DARLINGTON POINT

Review of FBA Assessment

November 2018

Report No. 4689/R01/V3/FINAL

**Management Zones**

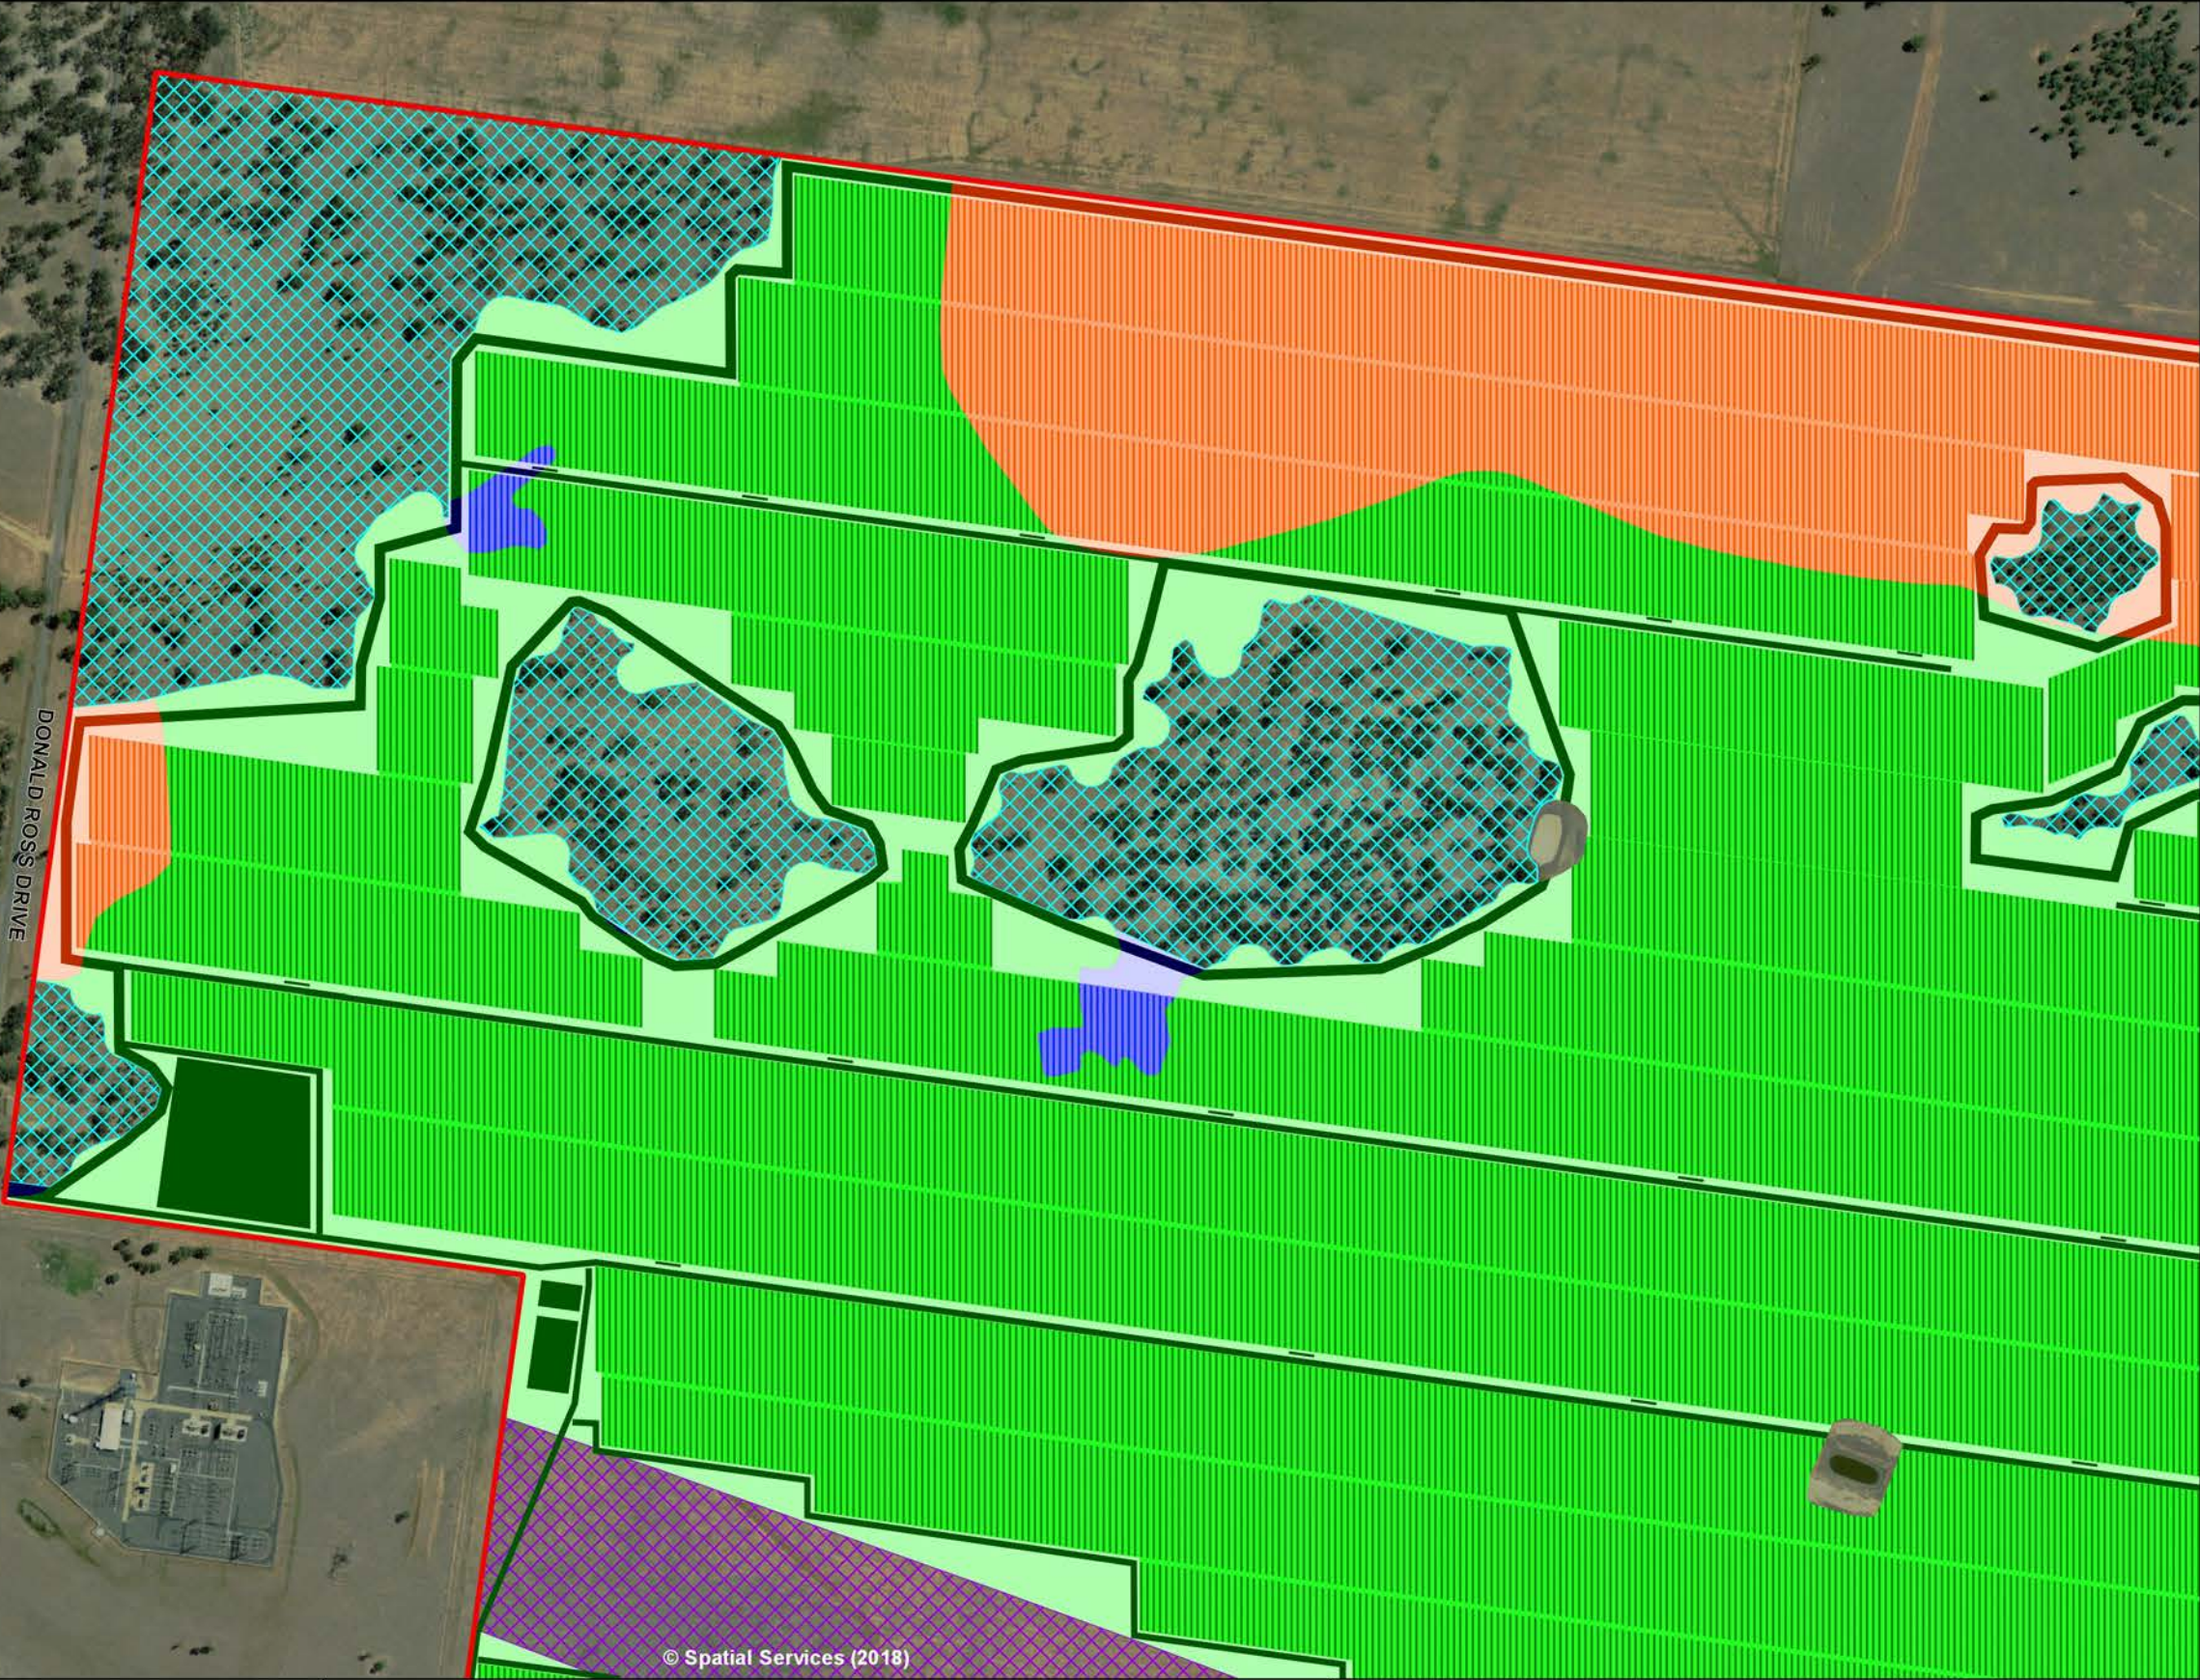
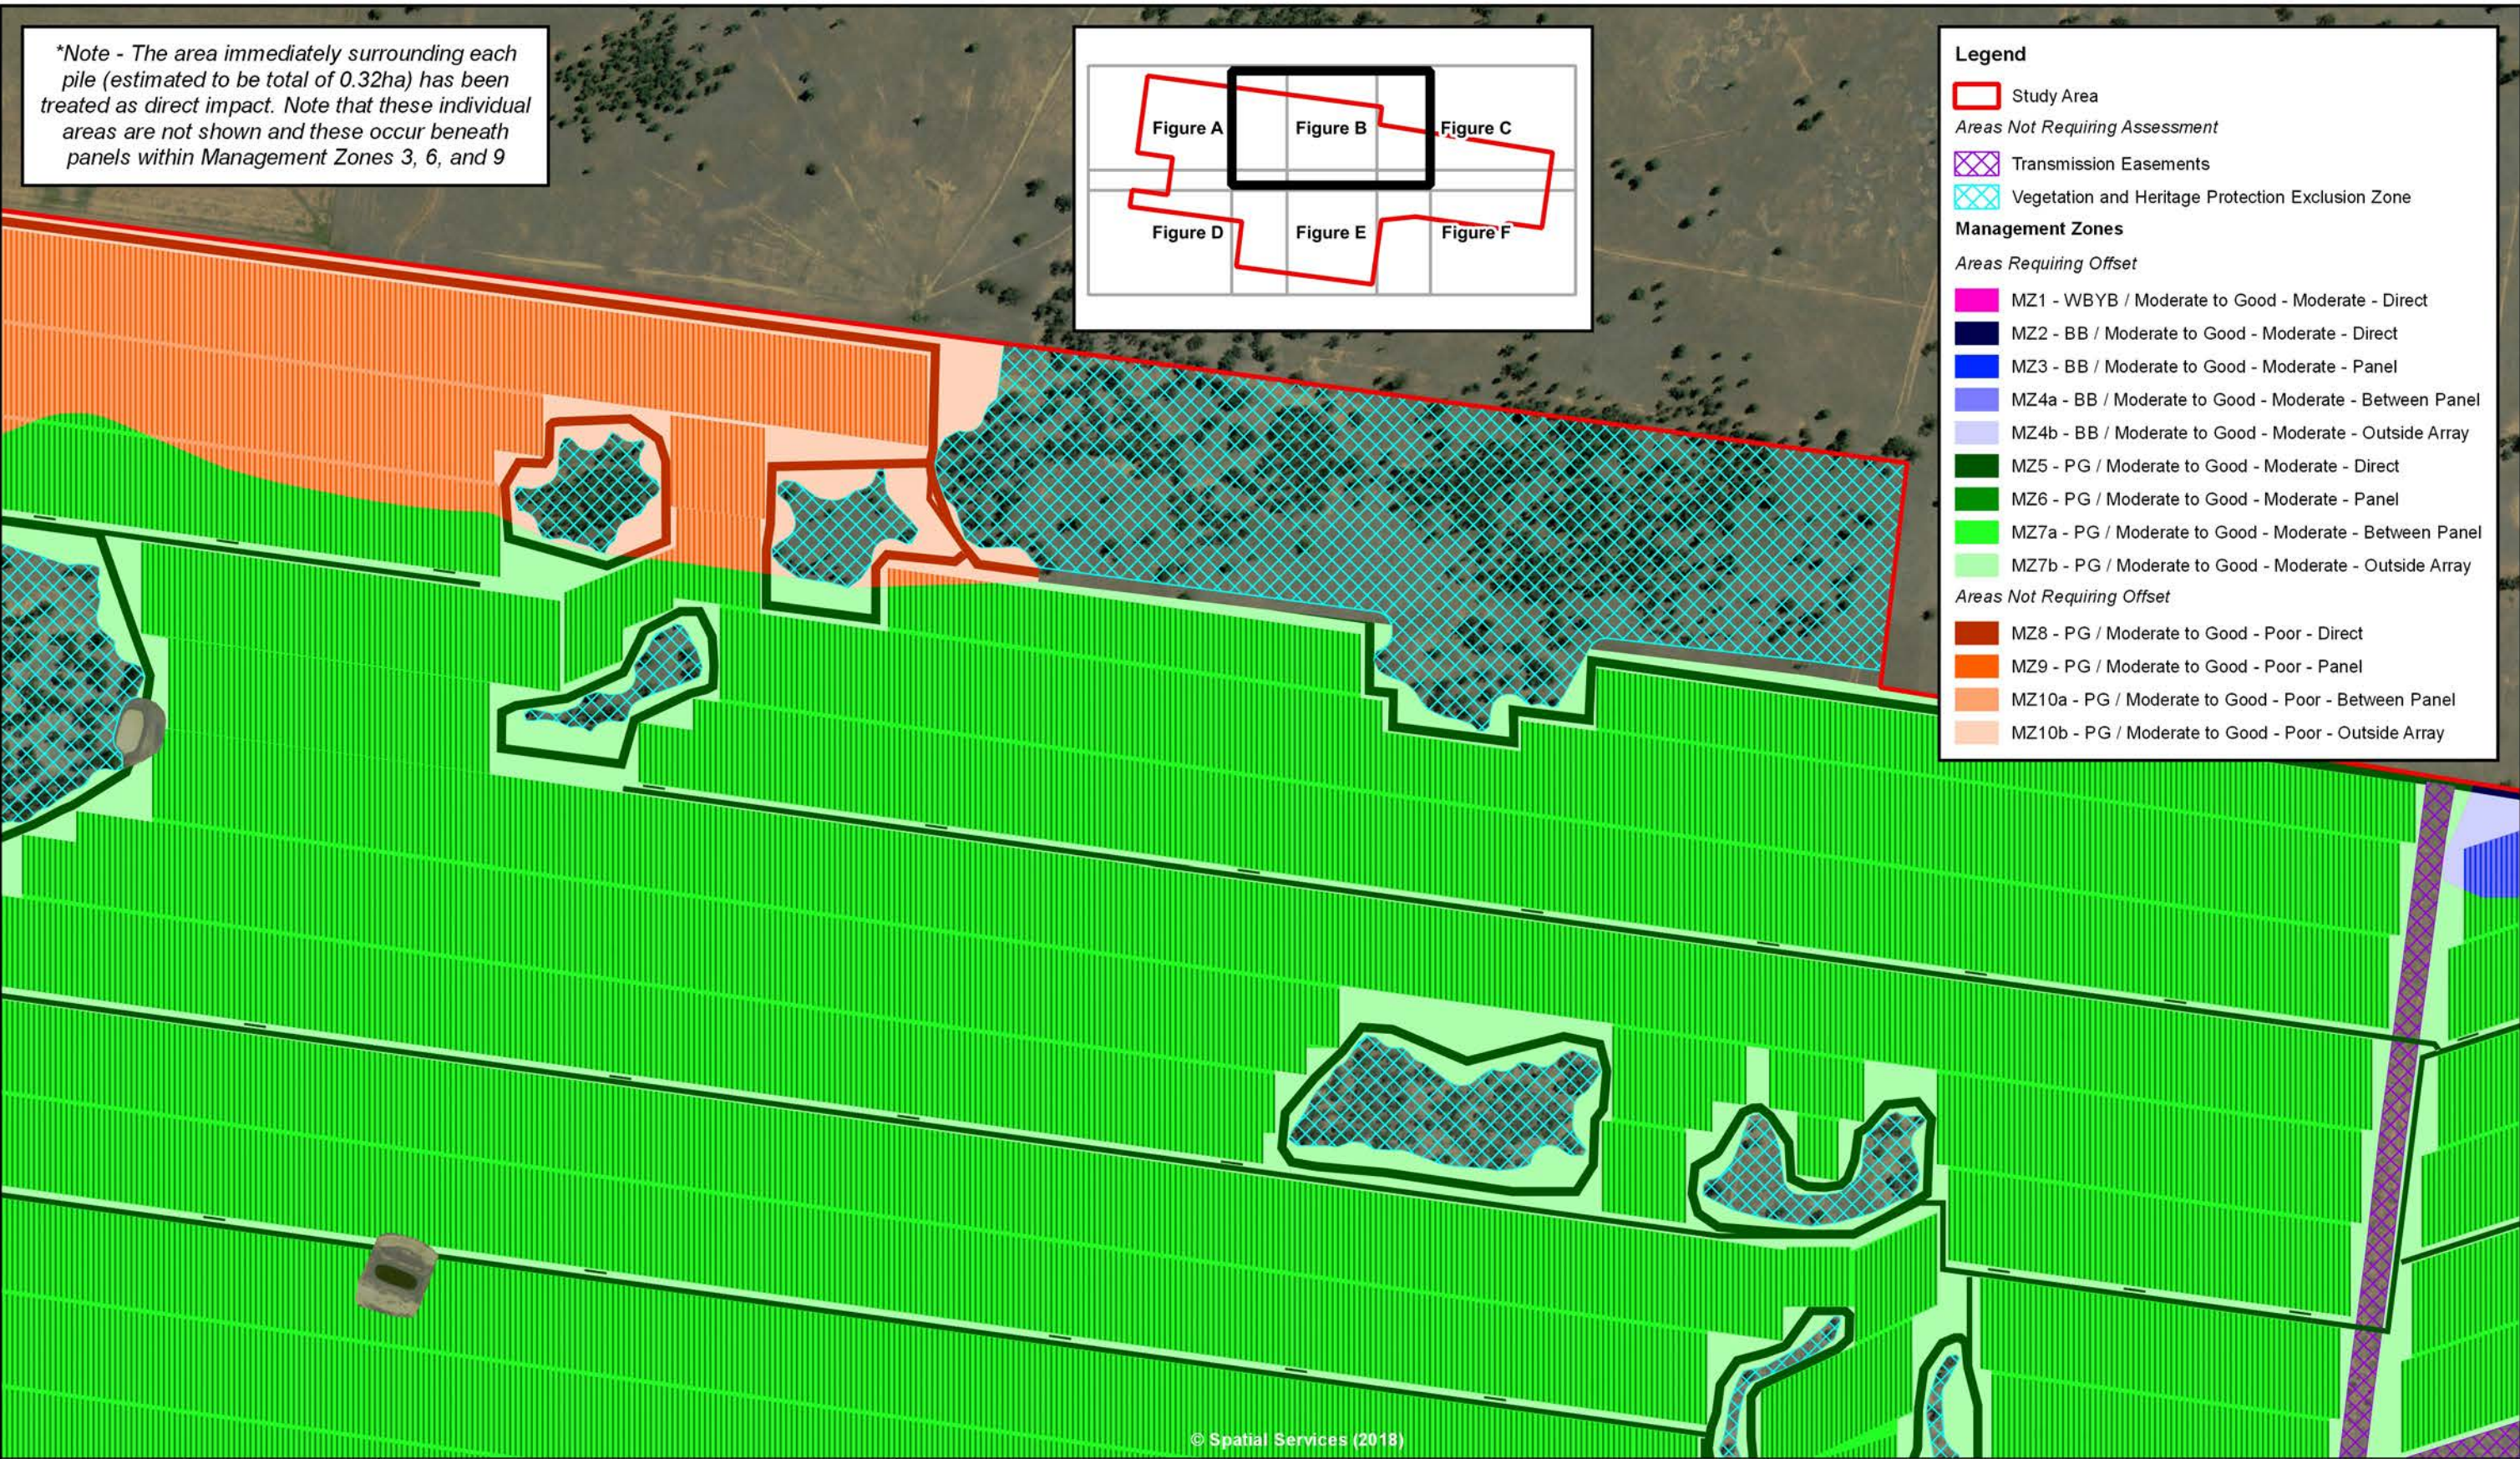
- B. The ‘Non-panel’ assessment zone is confusing because it includes grassland ‘between panel rows’ and ‘outside array’. These areas have different potential impacts. A map of management zones, in accordance with standard FBA methodology, would assist in understanding how biometric site score values have been apportioned [this is a reasonable request].

1. **The proponent should provide a map of management zones and indication of how future site score values have been apportioned across vegetation zones.**
